FULL PLANNING PERMISSION

Reference: H16-0829-15 **Date of Decision:** 26th October 2015
Applicant: Mr N Rangeley
36 West Parade
Spalding
Lincs
PE11 1HD

Location: 36 West Parade Spalding
Description: Two-storey rear extension

Site Block Plan
1 : 250

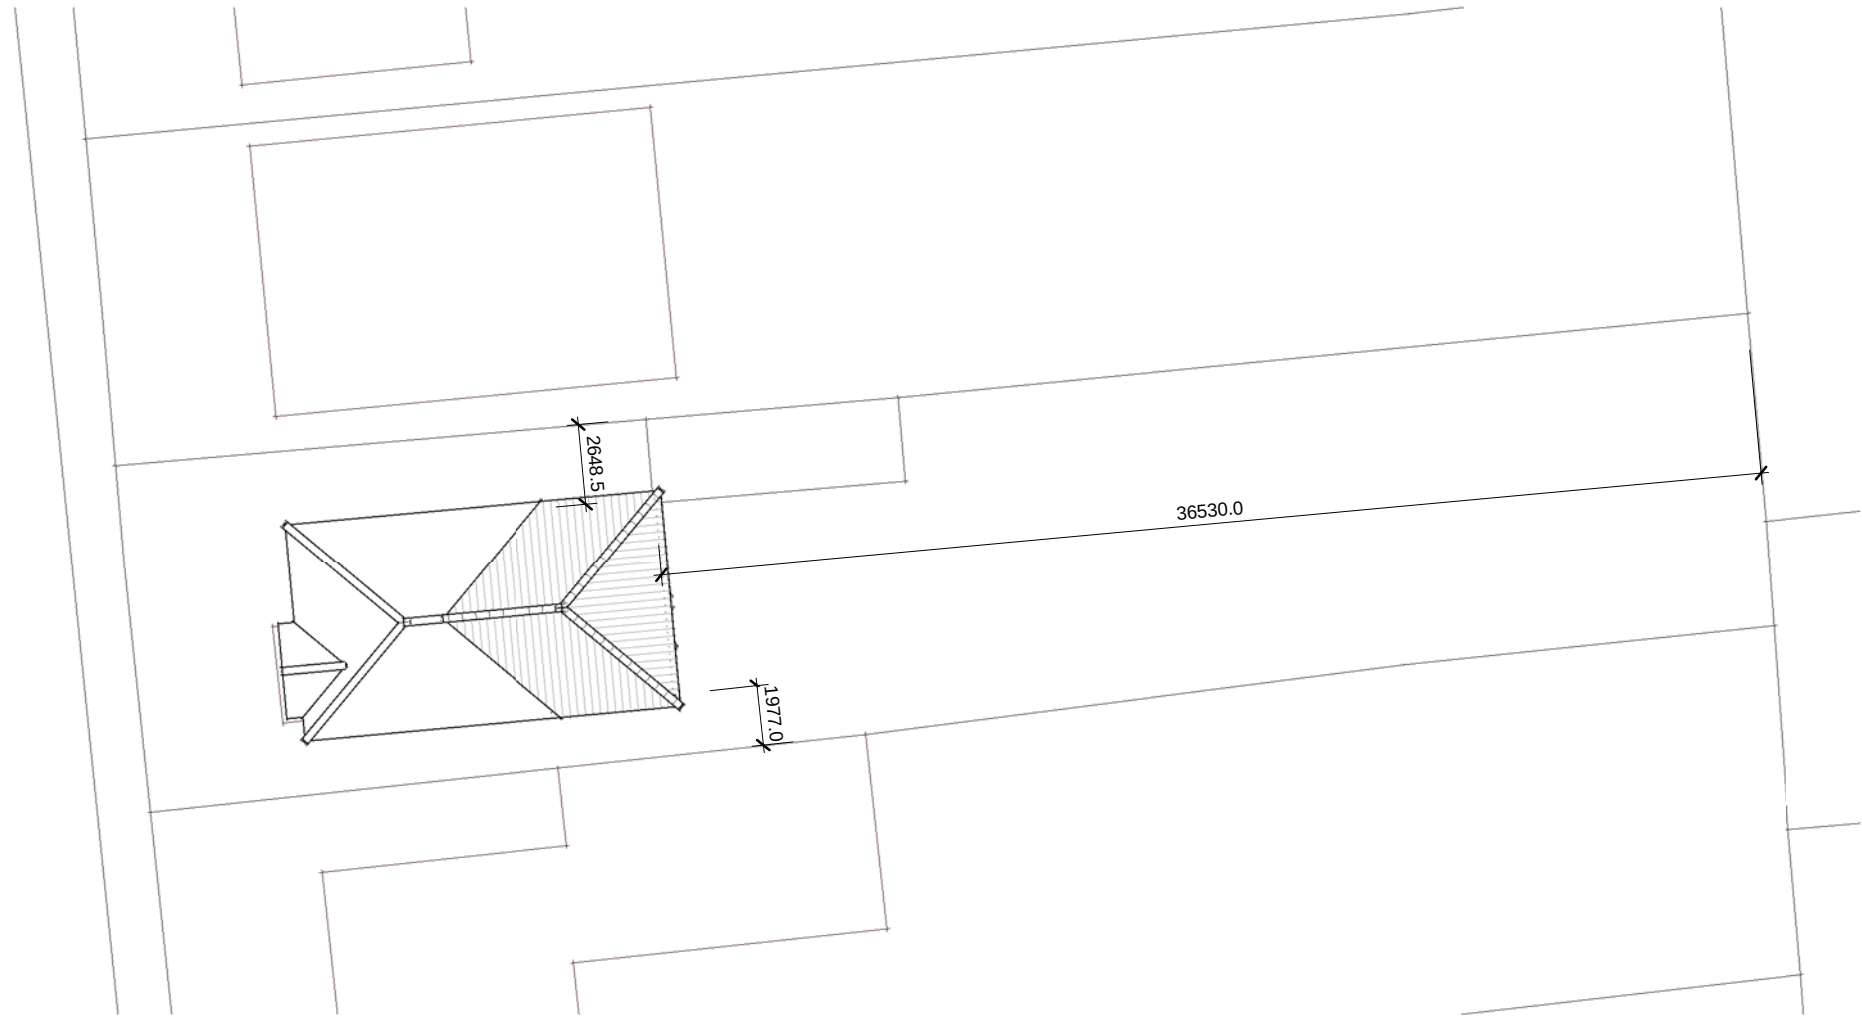
- 1 The proposed two-storey extension would be sited in very close proximity to the neighbouring property to the north, a bungalow at 38 West Parade, in a position which would unacceptably affect the outlook from main windows at that property and lead to an unacceptable loss of amenity at that property for current and future occupiers.

Proposed Elevations

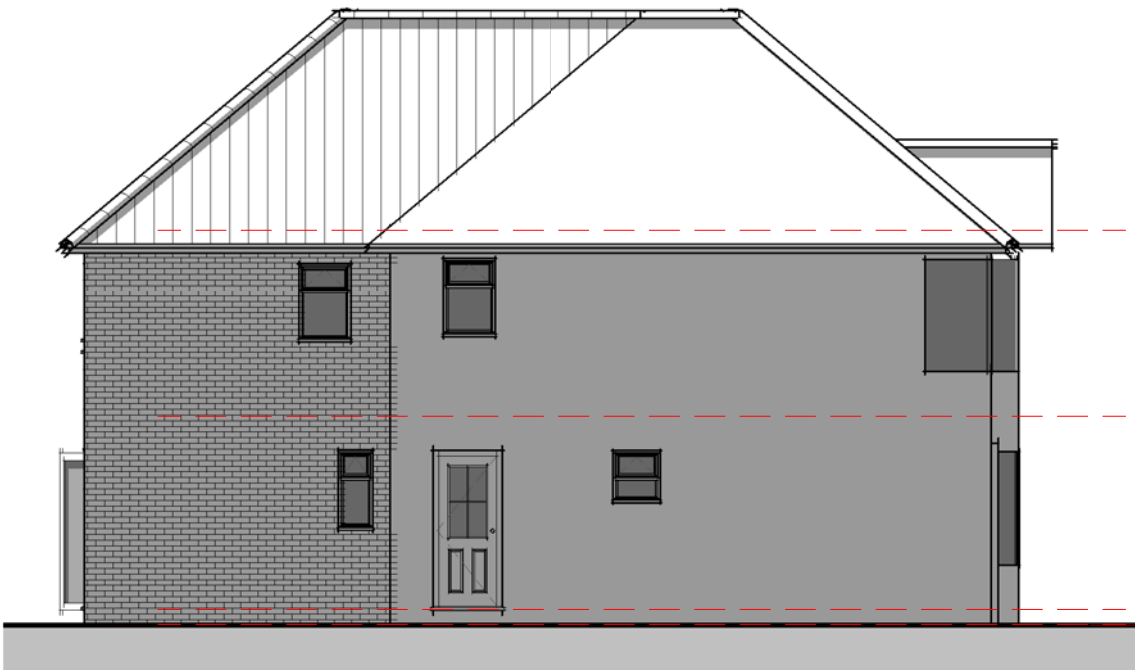
The window in question is the kitchen window which directly faces the proposed new two-storey extension. The kitchen has no other source of direct light and the impact would be significant, particularly in terms of loss of outlook, and would suffer from an overbearing effect.
